17-1528-MER

December 12, 2018

**Re: Blue Sea Village Mer Bleue
2159 Mer Bleue Road, Ottawa
Applications for Official Plan Amendment, Zoning Bylaw Amendment &
Plan of Subdivision, D01-01-17-0026, D02-02-17-0128, D07-16-17-0034**

FIGURE 2.2
CONCEPTUAL SITE PLAN

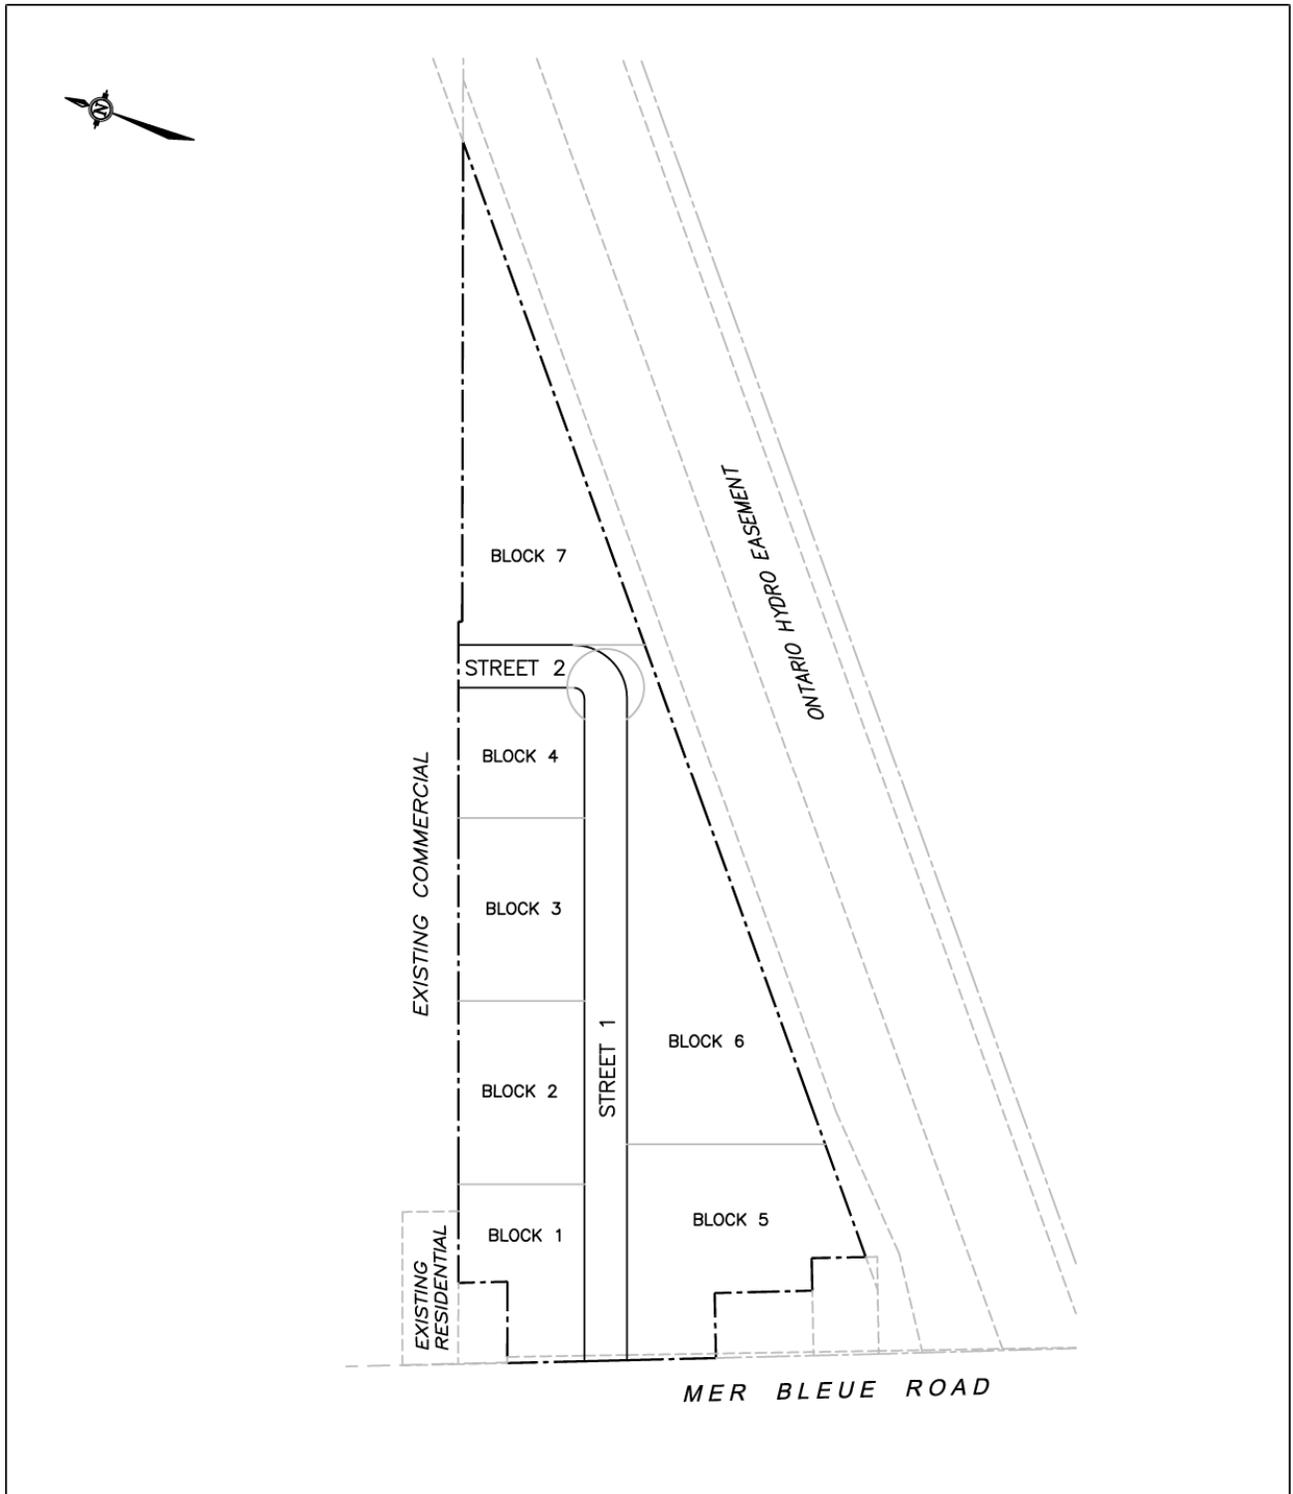
1. Please provide a 6-metre block that will allow for a connection from the public street to the hydro corridor to allow for future public cycling and pedestrian connections within the corridor. **This has been provided in the requested location, see revised Draft Plan of Subdivision**

2. Please provide an additional street connection to the north and walkway block to the south mid-way along street 1. The current block length of 300 m + is too long. **There is no technical requirement for such a public road to the north (see response from Traffic Consultants) and a single block at the easterly end of the temporary cul-du-sac is sufficient in our view to provide this connection. When individual blocks along the corridor are advanced, we are confident that the City will ask for connections from those blocks to the corridor which should suffice.**
